From: Contact Centre (CRM) <contact@ribblevalley.gov.uk>
Sent: 06 March 2023 18:21
To: Planning
Subject: Planning Application Comments - 3/2023/0076 FS-Case-494115857

Planning Application Reference No.: 3/2023/0076

Address of Development: 23 elswick gardens mellor

Proposed Front Elevation
Scale (1 : 1 0 0)

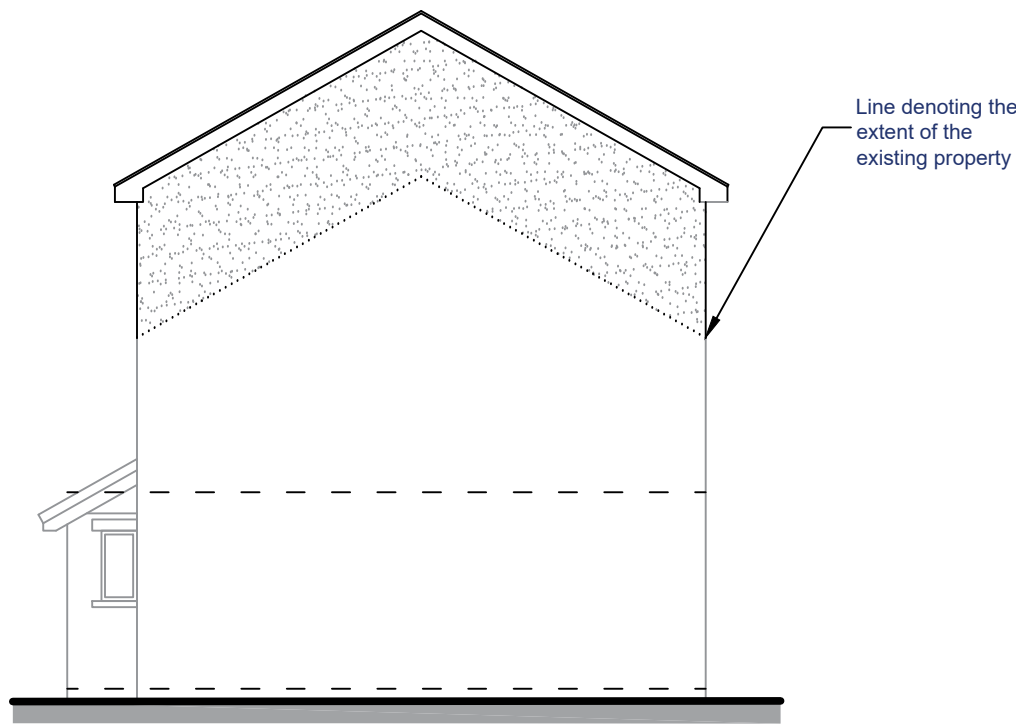
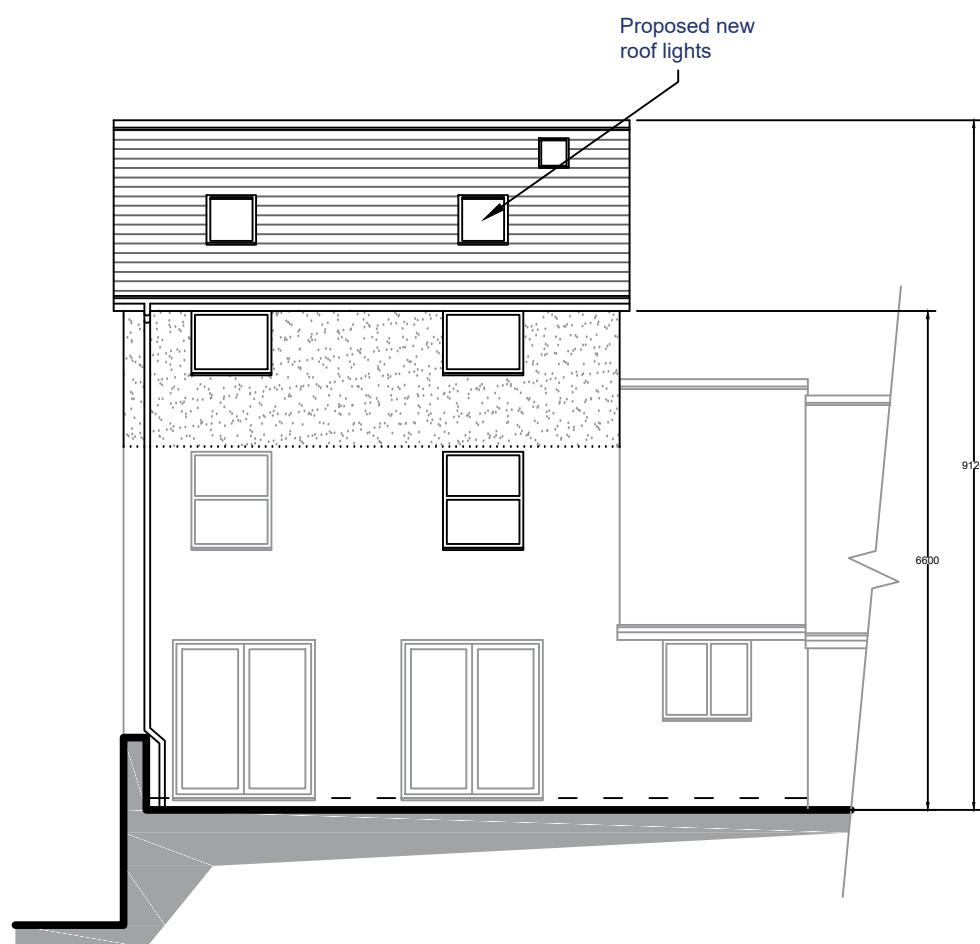
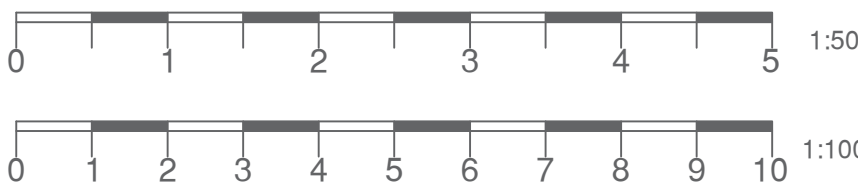
Comments: We are concerned that raising the height of this dwelling will reduce light [REDACTED]

Comments: We are concerned about [REDACTED] The additional height on the house will look [REDACTED]
